Botley West Solar Farm Ref: EN010147 - Deadline 1: June 4th 2025
For the attention of the Planning Inspectorate. Our reference number: RR 0413

Botley West Solar Farm: Written Representations, absorbing information from earlier submissions, accompanying ICOMOS-UK's Registration as an Interested Party, including a Summary and overlays on the Applicant's 'Botley West Solar Farm Preliminary Masterplans'.

These comments and Masterplan overlays are from the Cultural Landscapes and Historic Gardens Committee of ICOMOS-UK.

Project: AG1803	Sheet: Field 2.100
Date: November 2024	
Scale: 1 : 4000 @A3

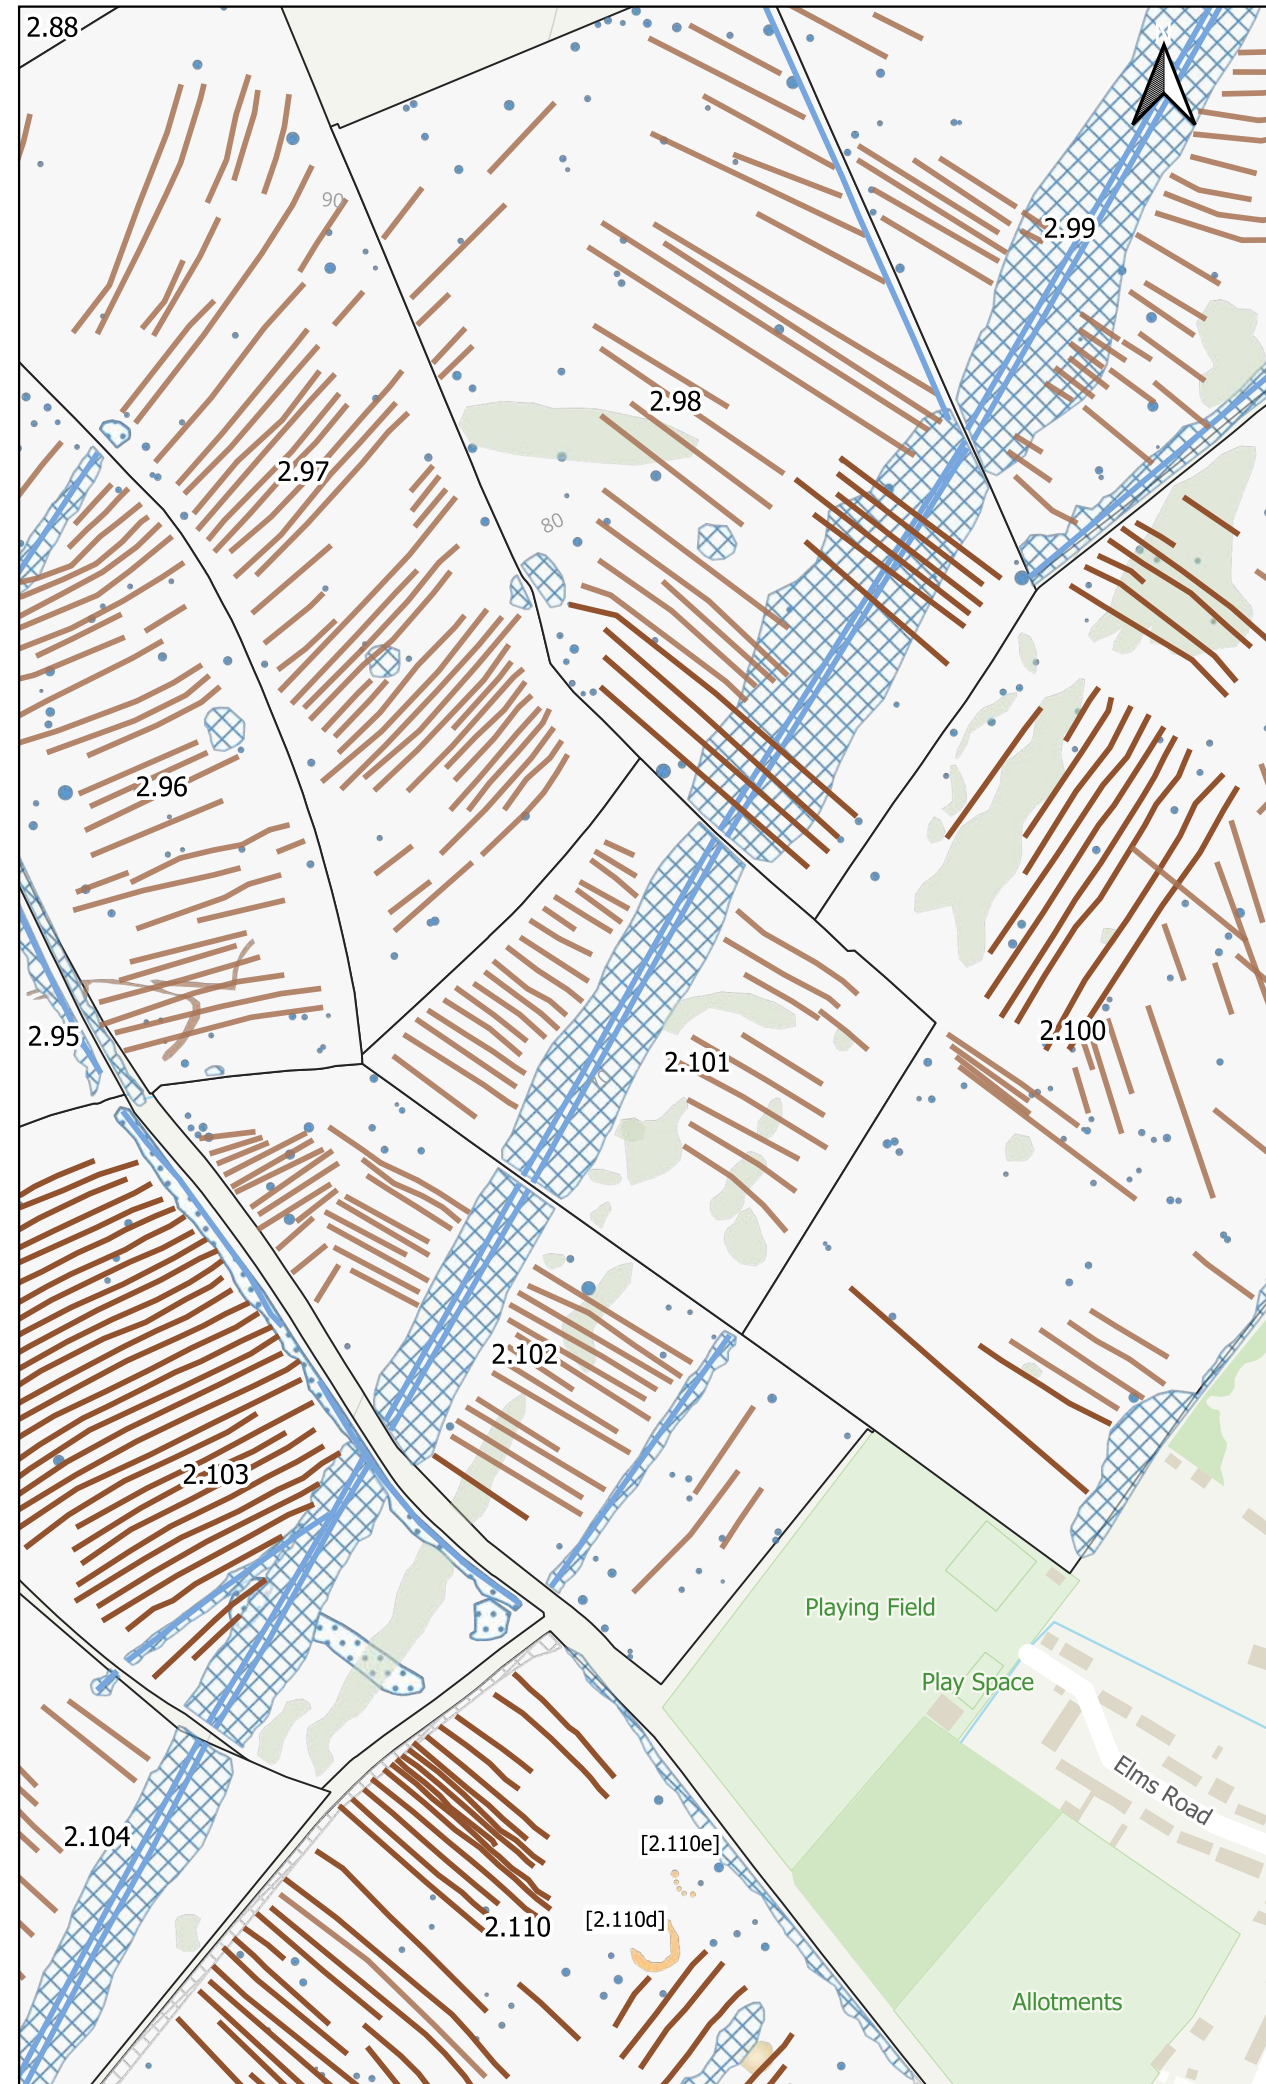
Much of the 3km long middle block north of the railway and on either side of a minor road, including the slightly detached surroundings of a sewage works, is on a kind of plateau of gently rising ground where solar arrays could be made comparatively inconspicuous from without if surrounded by tall wide dense hedges. This applies also to its detached northern end (Middle Section 1) which, though a place where a solar farm would have a detrimental local impact, does not appear to impinge upon the nearby 'high scenic value' land S-W of Blenheim Park and the wooded south of Blenheim Park itself (Preliminary Masterplan-Middle Section 1). However, solar arrays are proposed far too close to Cassington village. There should be wide open fields between the NW edge of Cassington village with dense new hedges planted along the solar array boundary. **The fields NW of Cassington village should be excluded from development to provide the village with breathing space [2.110; 2.102 southern two thirds; 2.100 southern third].**

Project: AG1803	Sheet: Field 2.105
Date: November 2024	
Scale: 1 : 4000 @A3

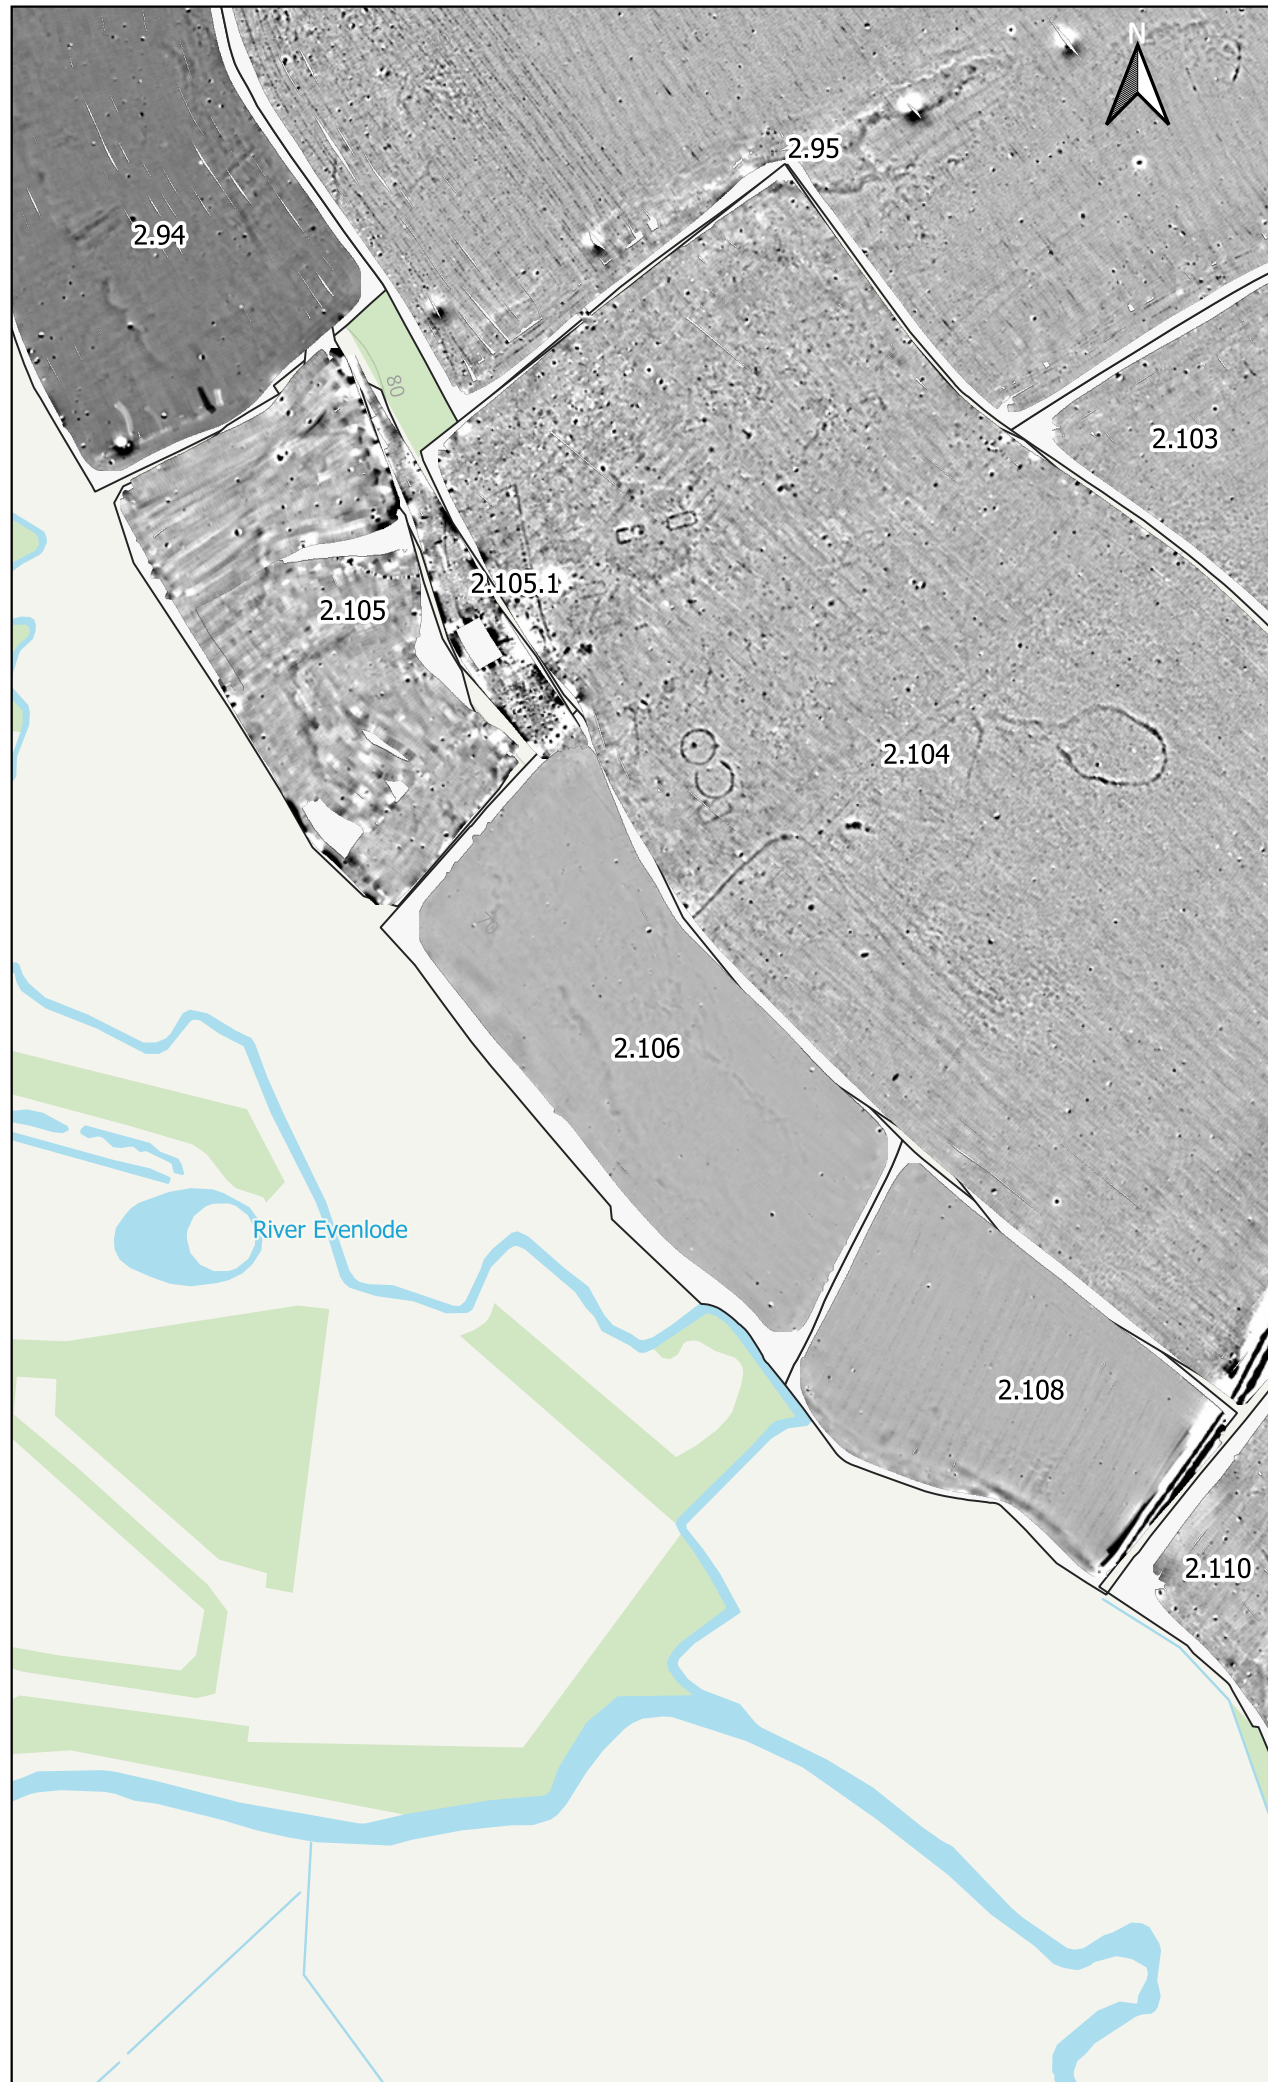
The surroundings of the lovely Evenlode valley are a very unsatisfactory part of the Applicants' proposals. It is unacceptable to place solar panels on the steep west facing escarpment along the east side of the Evenlode valley, itself wisely excluded from proposed development. It is as if the topography of the landscape has not been analysed, as if no independent landscape mind has been involved. **There should be no solar panels on any of the escarpment on the east side of the Evenlode Valley [2.37; 2.38; 2.72; 2.74; 2.75; 2.78 north half; 2.80; 2.81; 2.82; 2.86; 2.89; 2.94; 2.105; 2.106; 2.108; 2.109].**

Project: AG1803	Sheet: Field 2.111
Date: November 2024	
Scale: 1 : 4000 @A3

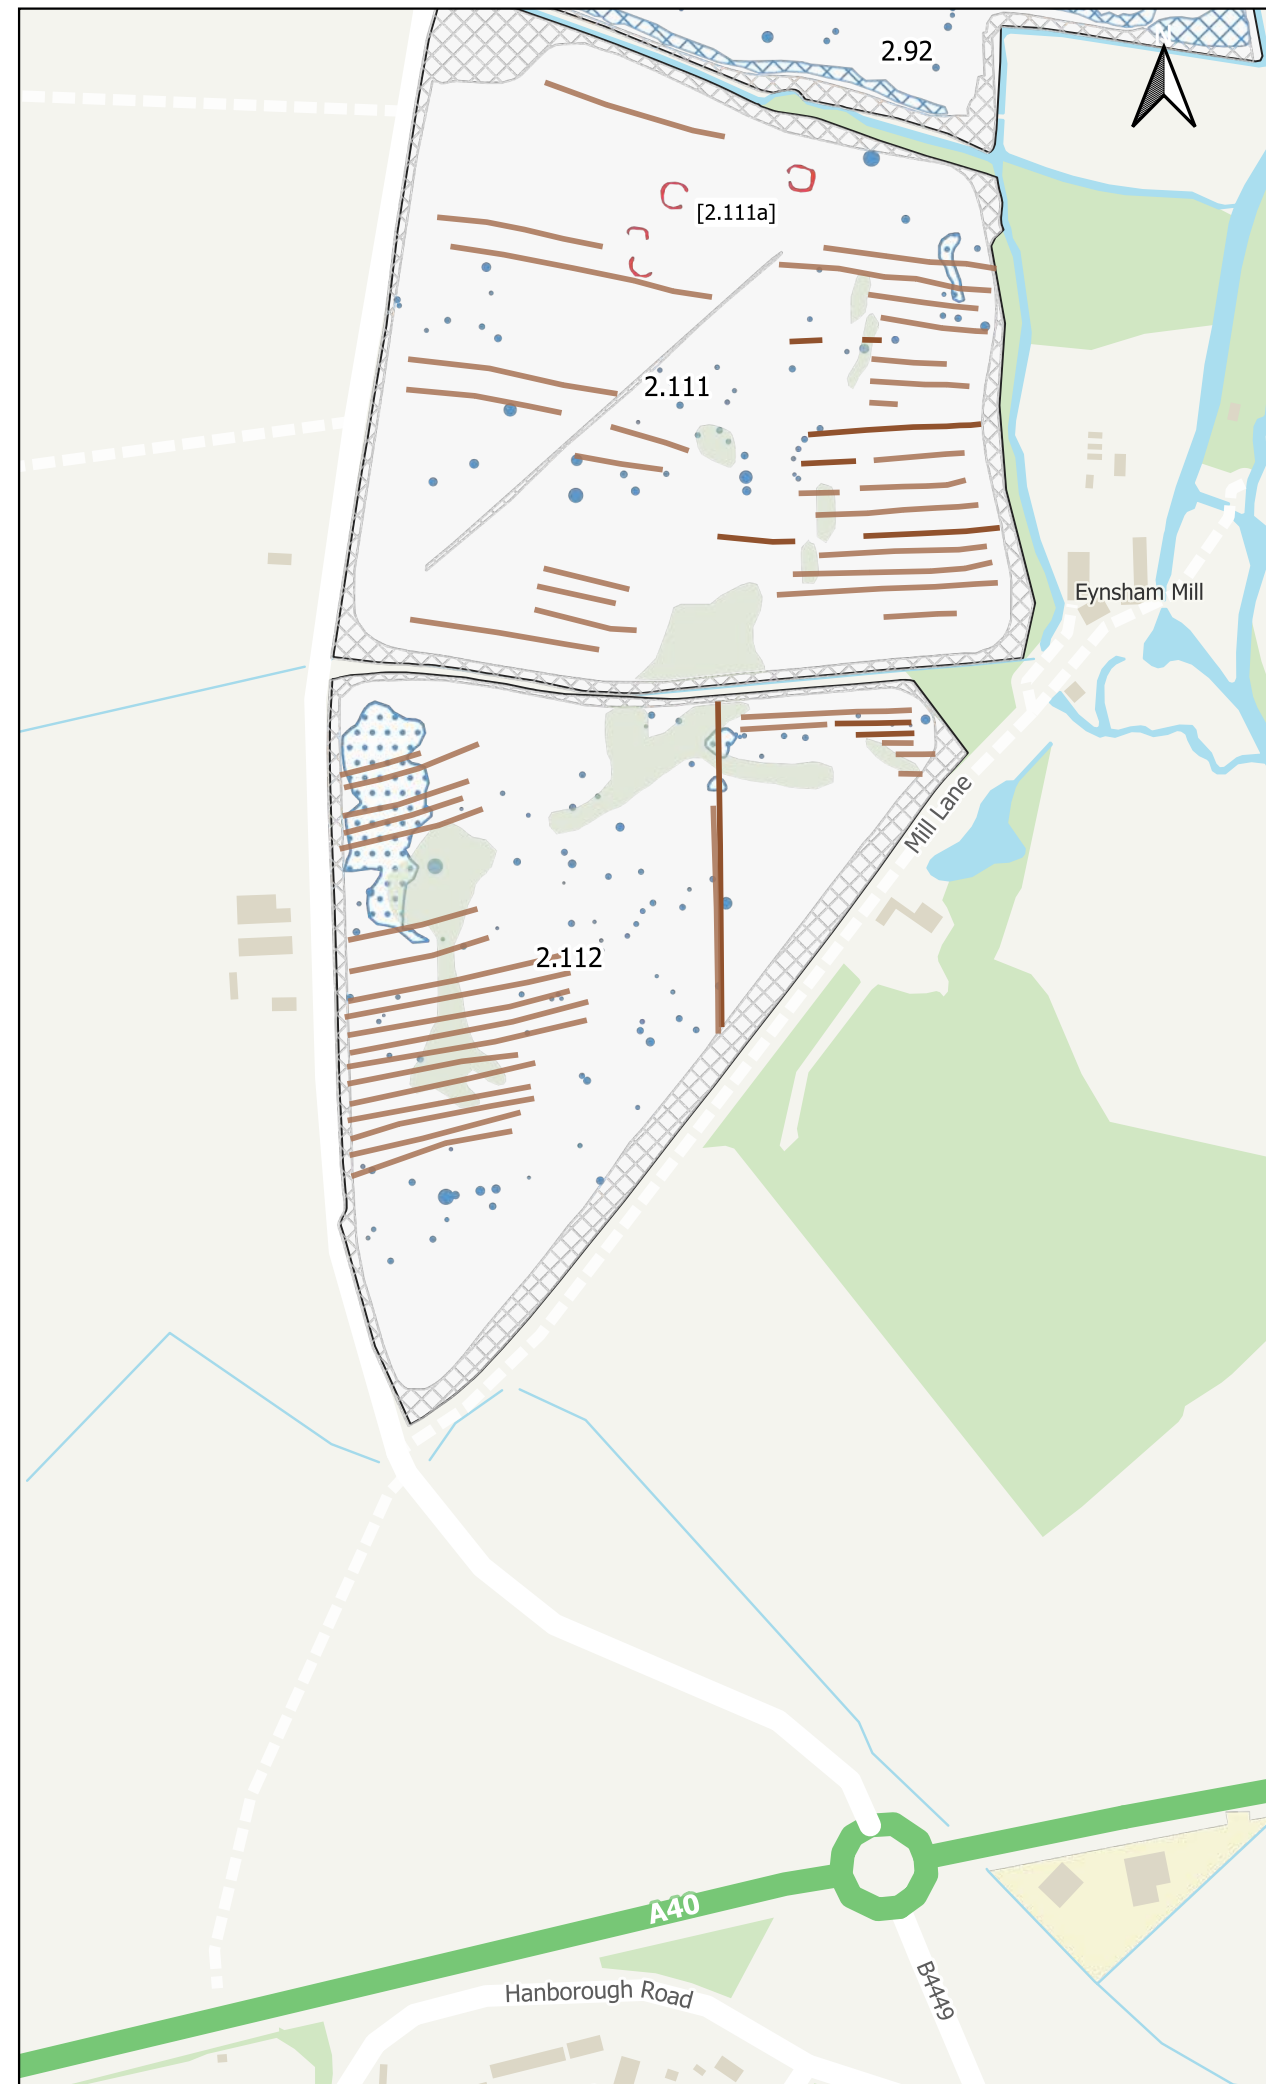
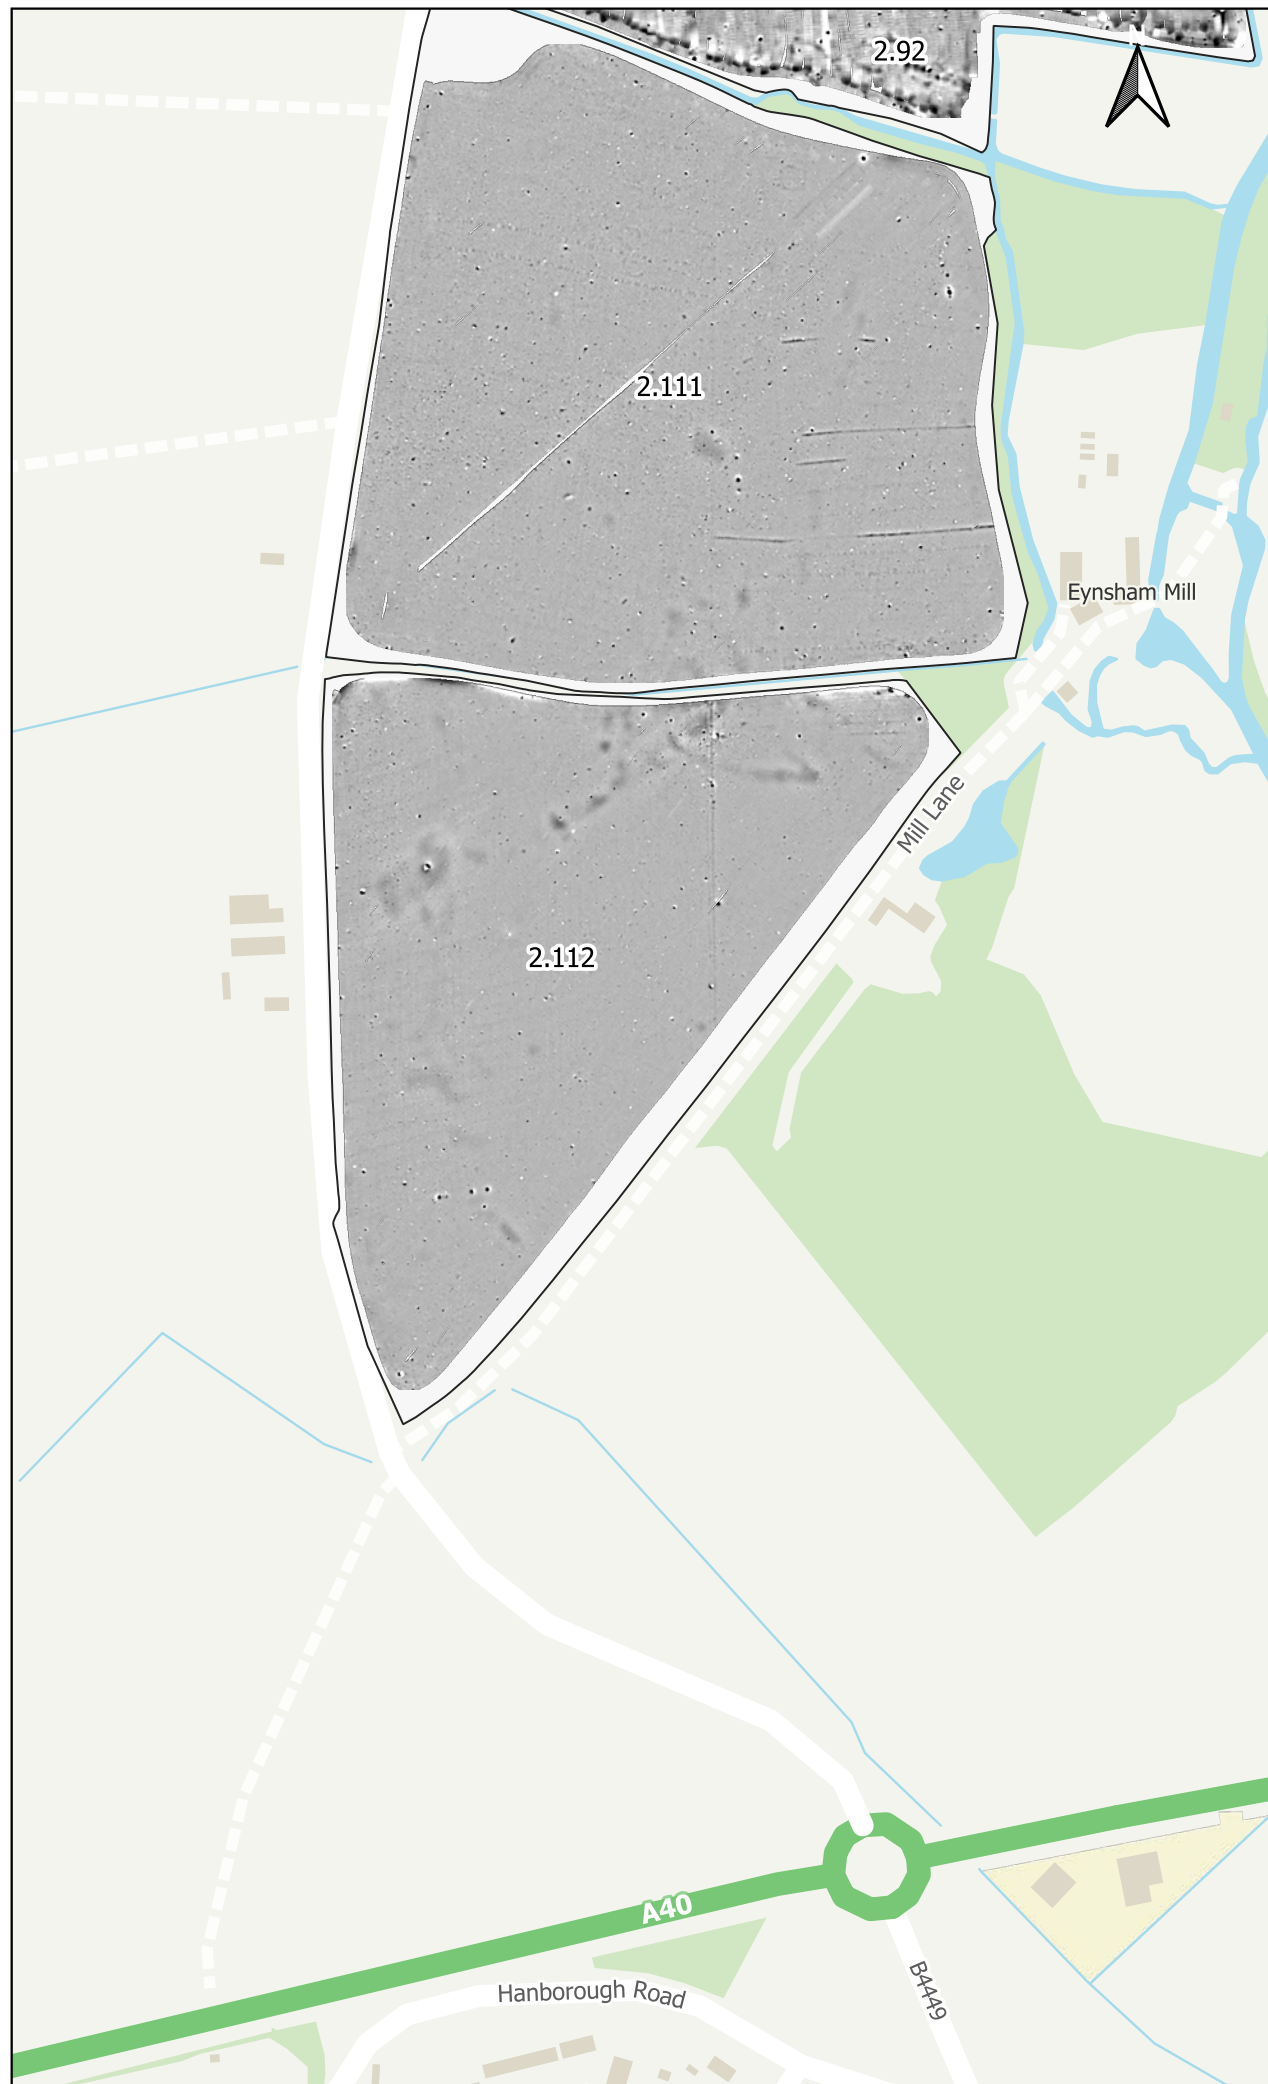
No attention has been paid to the conservation of the important north-easterly views identified on the Salt Cross Garden Village spatial framework as *panoramic views*. Salt Cross is a new village to be built beside the Oxford green belt west of Oxford. To conserve these panoramic views across the Evenlode valley to the escarpment on its north-eastern flank, **all the fields near the north-east of Salt Cross should be excluded from consideration for solar farm development [2.97; 2.92; 2.111; 2.112; 2.113; 2.114]** (as indicated on Masterplan-Middle Section 3).
